10 April 2018

Your Reference: SSD 6084 MOD 1
Our Reference: OUT18/4505

Re: Austen Quarry Extension Project – Modification 1 (SSD 6084 MOD 1)

Figure 2: Approved and proposed quarry layout

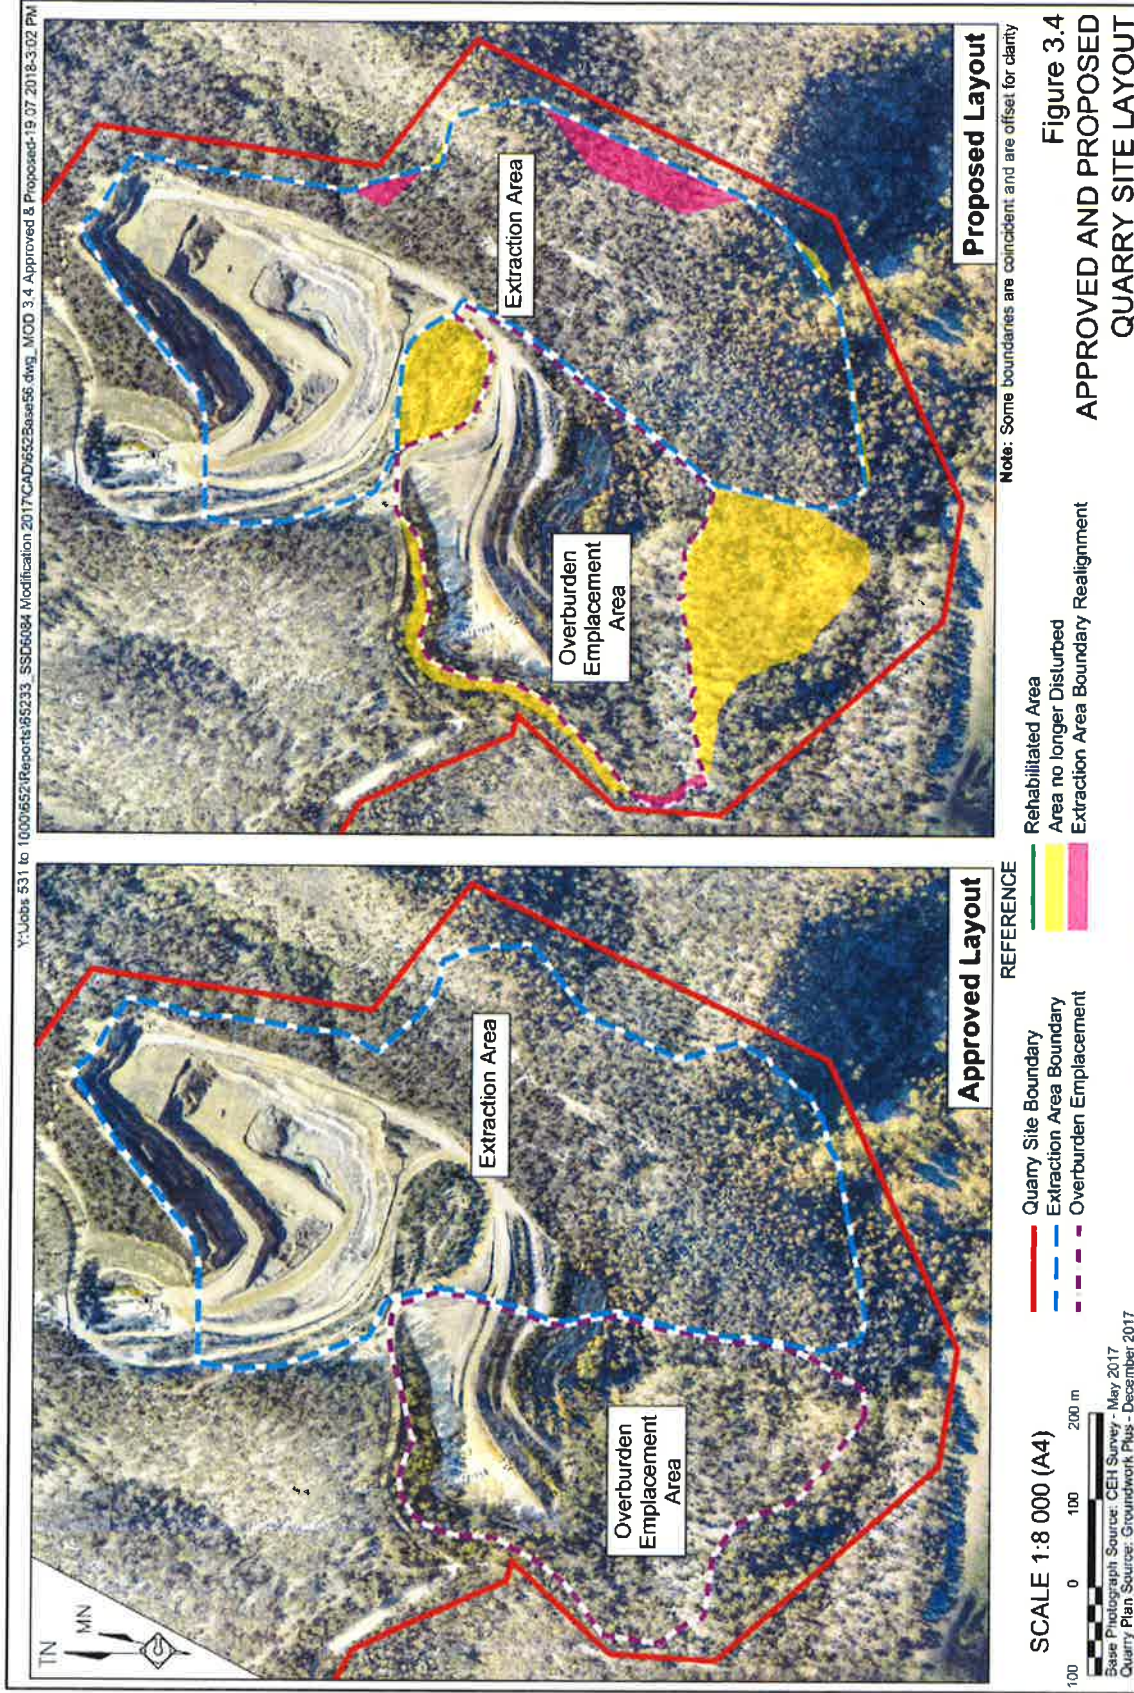
In relation to biodiversity offsetting obligations, under current consent conditions the area labelled "Rehabilitation Area (Offset for Clarity)" on Figure 3.1 (Refer to page 31 of SoEE) was to be extracted. The resources in this area will be sterilised should it be reserved for biodiversity offsetting obligations as proposed by MOD 1. Further, GSNSW notes current consent conditions for SSD 6084 included a 94.3 hectare Biodiversity Offset Area located adjacent to the eastern boundary of the Project. MOD 1 proposes to modify existing consent conditions to reflect the retirement of biodiversity credits only.
